In future correspondence please refer to:
Project Tracking Code: 2021-03-01553
Property: Kittitas County_Swiftwater Storage Project (CU-20-00006)
Re: Inadvertent Discovery Plan Requested

TO: Community Development Services
FROM: Public Works Plan Review Team
DATE: March 16, 2021
SUBJECT: CU-20-00006 Swiftwater Storage

SUBJECT: WDFW COMMENTS ON SWIFTWATER STORAGE CU-20-00006

Re: SEPA Register 202101042, CU-20-00006

WLC PROPERTY HOLDINGS LLC
SITE PLAN

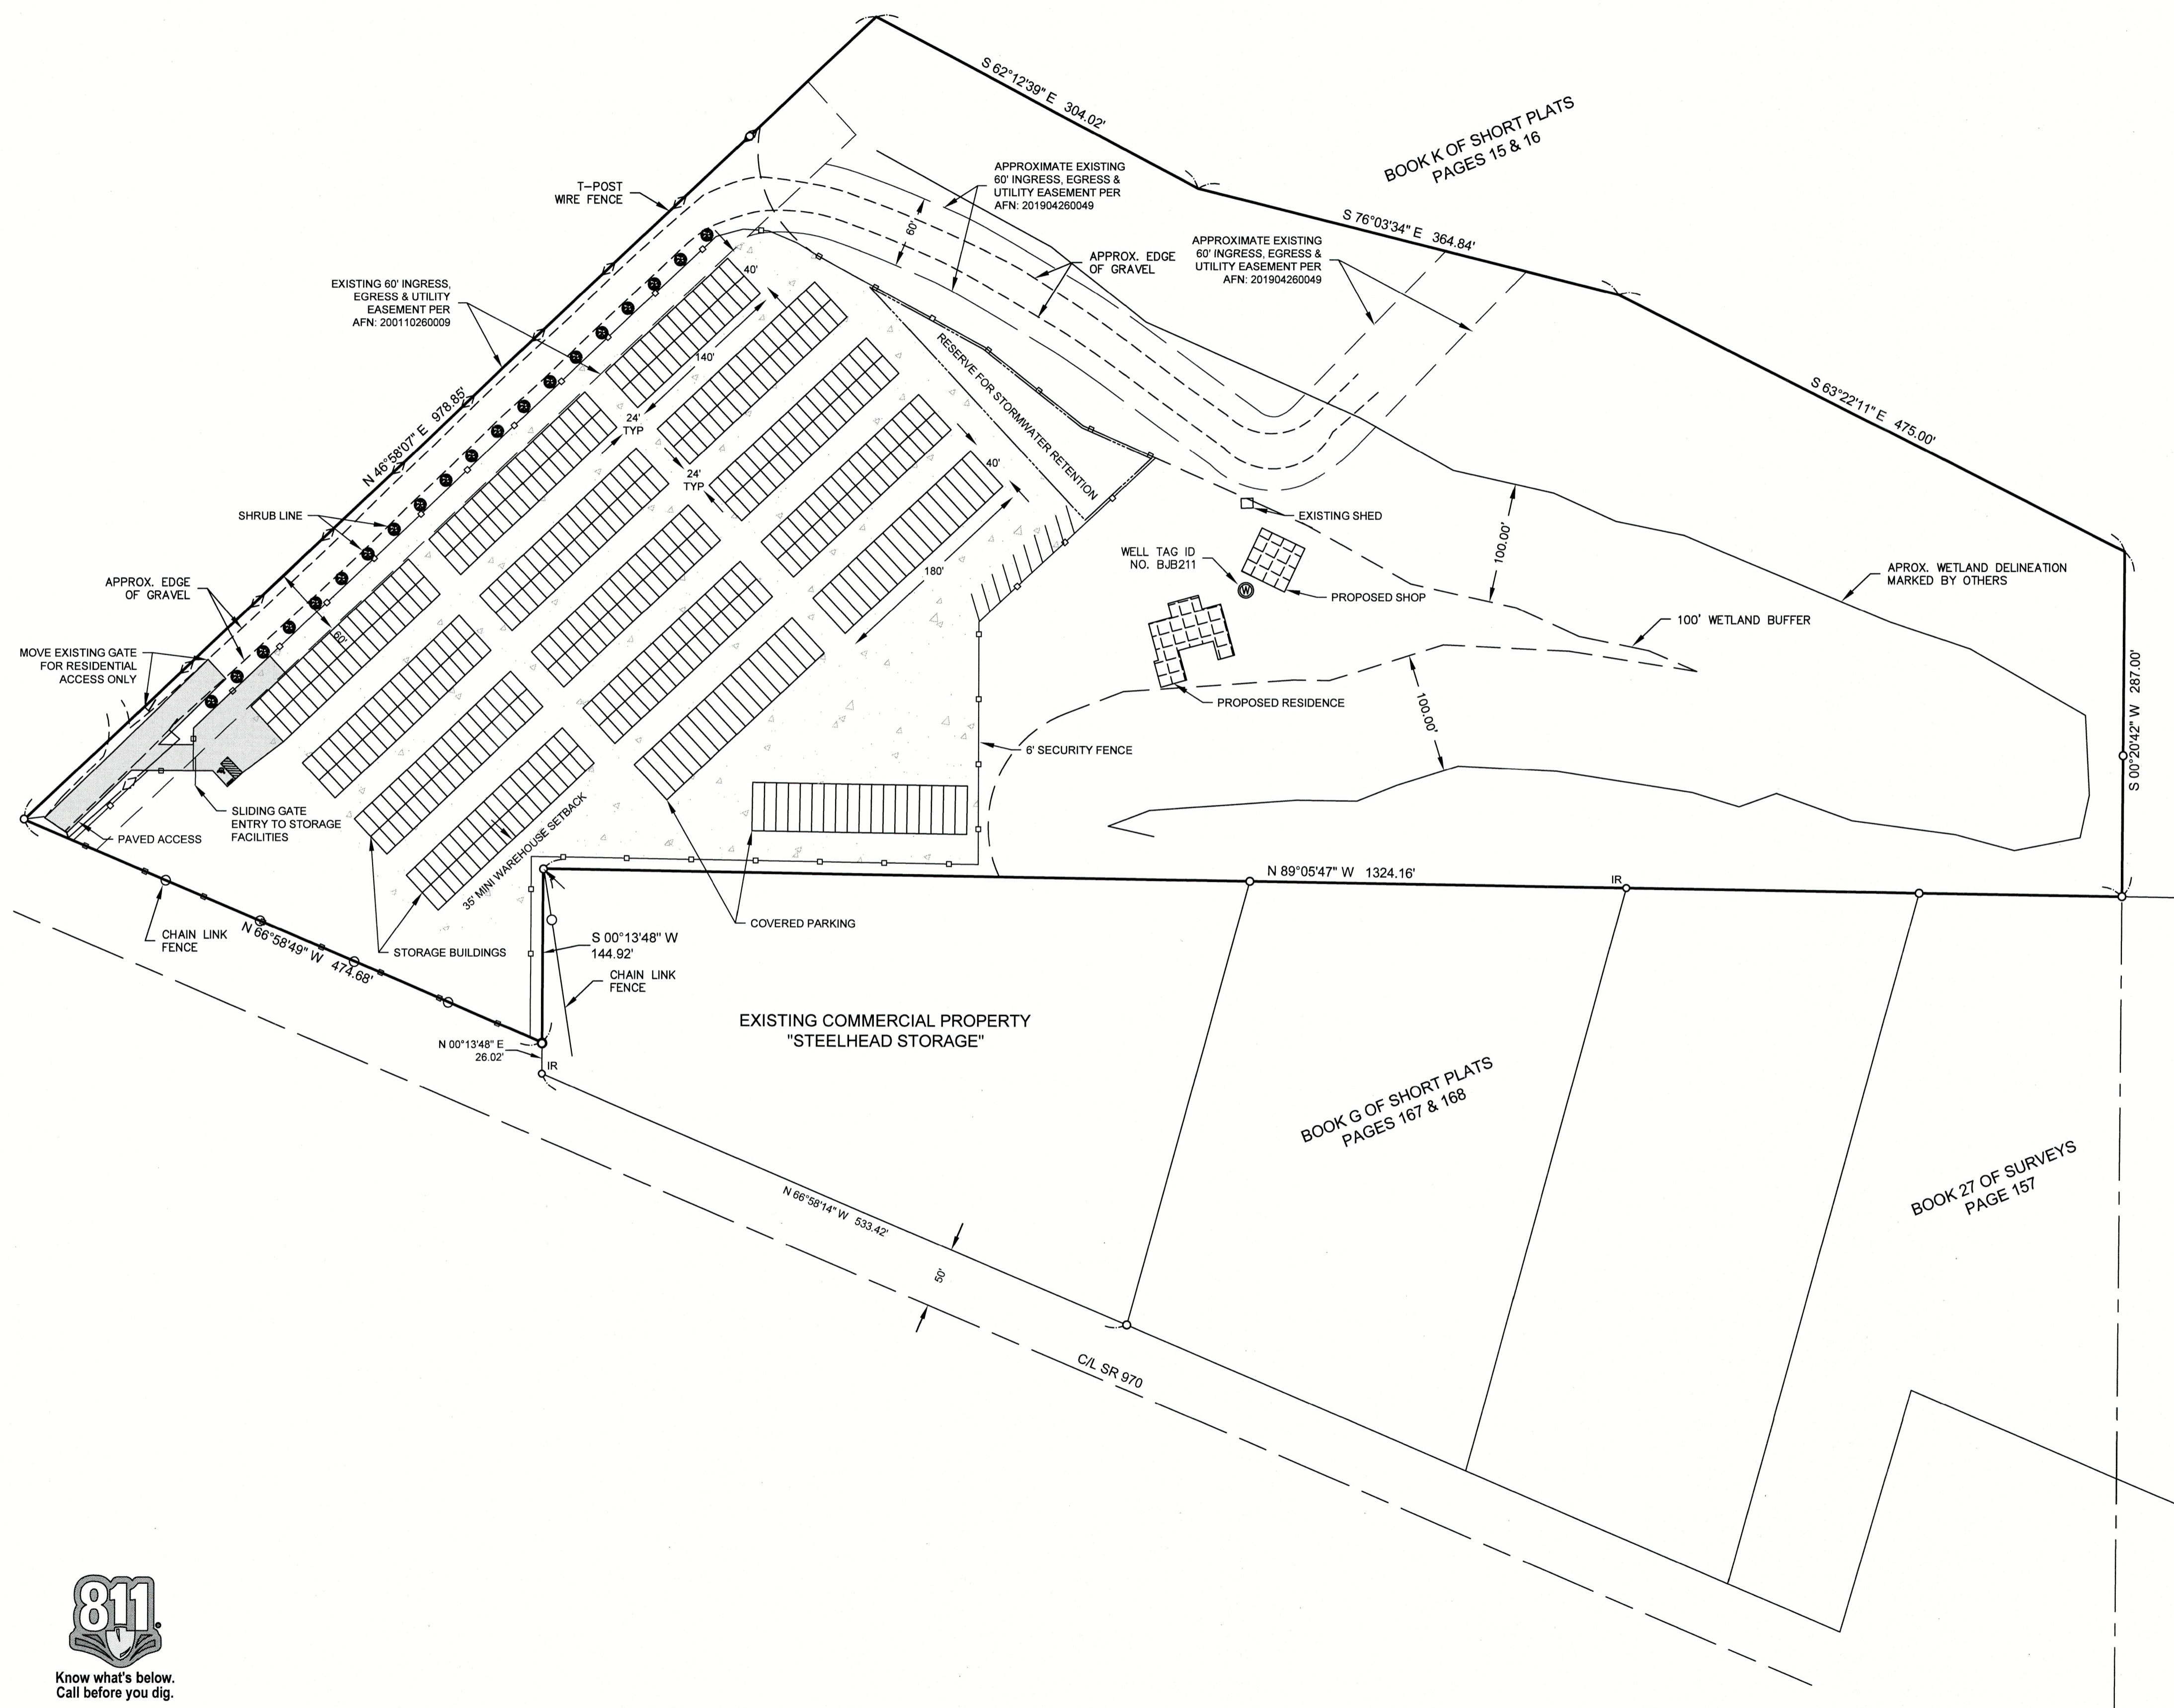
Border with Todd Crooks. Trees beyond gravel road to be removed per drawing, eliminating any buffer

While the application materials address the Fish and Wildlife Habitat Conservation Areas and Wetlands on the property, they do not adequately address Frequently Flooded Areas. Nearly the entire parcel is mapped within the 100-year floodplain and yet the materials provide little information for how the site will be graded or potential compensatory floodplain mitigation measures. The flows within the wall-based channel on this property fluctuate seasonally with flows in the Yakima River. This is common with wall-based floodplain channels like the stream on this property. The water table on this property likely fluctuates in a similar manner. The depth to groundwater during all seasons will be critical to understanding the effectiveness of compensatory floodplain mitigation measures as well as stormwater treatment. The stormwater treatment area shown is adjacent to the wetland/stream buffer and we have concerns that there will not be adequate separation of the stormwater from these critical areas.

- Final site grading should be available for review to understand how the changed topography may or may not impact the associated critical areas and their functions and values.

The buffer width should be vegetated prior to construction. As there is a change in landuse the buffer must be planted. Without a planted buffer the storage unit should be located even further away from the wetland. Planting the buffer will reduce noise, dust and other pollutants from entering the wetland, and provide structure adjacent to the wetland.
